From: Plant, Tom - Communities <Tom.Plant@Oxfordshire.gov.uk>
Sent: 17 November 2020 16:01
To: Gemma Magnuson
Cc: DC Support; Cllr Ian Corkin
Subject: 20-02827-F - Orchard House Church Lane Wendlebury OX25 2PN

Planning application: 20/02827/F
Location: Orchard House Church Lane Wendlebury OX25 2PN
Description: Change from residential care home (C2) to a single-family dwelling (C3) and build double storey rear extensions to form additional living area and bedrooms.
Type: Full Development
Case Officer: Gemma Magnuson

Site Plan  
Scale: 1:500

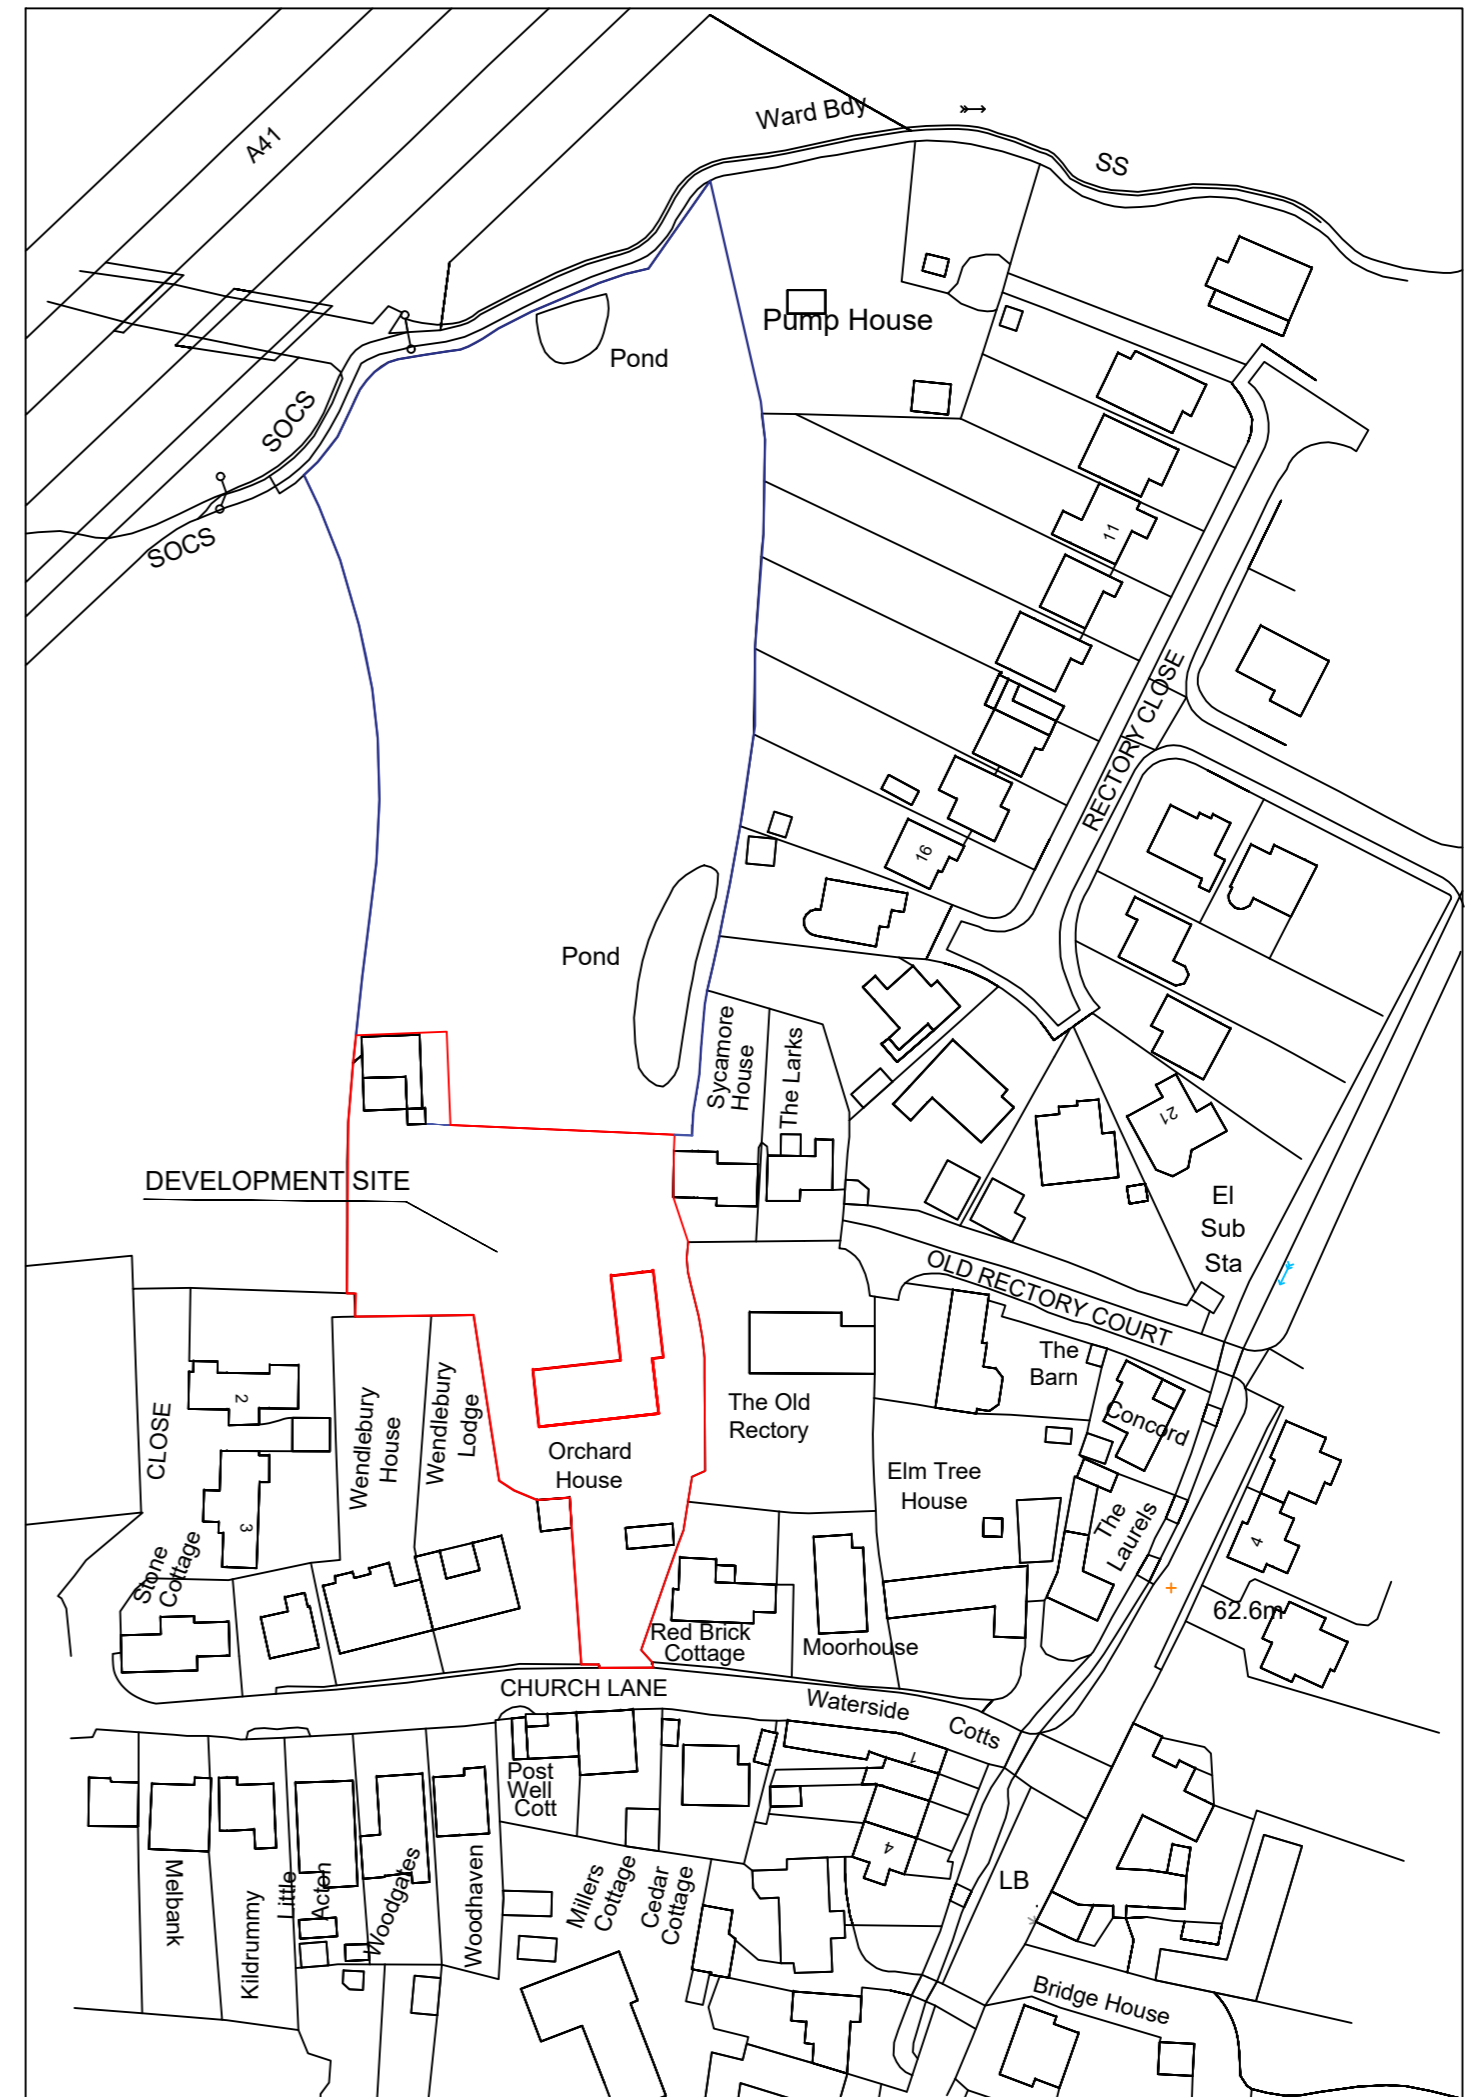
Prior to the first occupation of the development hereby approved, the parking and manoeuvring areas shall be provided in accordance with the plan approved (Drawing No. 05) and shall be constructed from porous materials or provision shall be made to direct run-off water from the hard surface to a permeable or porous area or surface within the curtilage of the site. Thereafter, the parking and manoeuvring areas shall be retained in accordance with this condition and shall be unobstructed except for the parking and manoeuvring of vehicles at all times. Reason - In the interests of highway safety and flood prevention and to comply with Policies ESD7 and ESD15 of the Cherwell Local Plan 2011-2031 Part 1 and Government guidance contained within the National Planning Policy Framework.

The proposals are unlikely to have any adverse impact upon the local highway network from a traffic and safety point of view, therefore I offer no objection, subject to a condition requiring the outbuilding to remain ancillary to the main dwellinghouse and that any additional hardstanding is made of a porous materials or provision shall be made to direct run-off water from the hard surface to a permeable or porous area or surface within the curtilage of the site, in the interest of sustainable drainage.
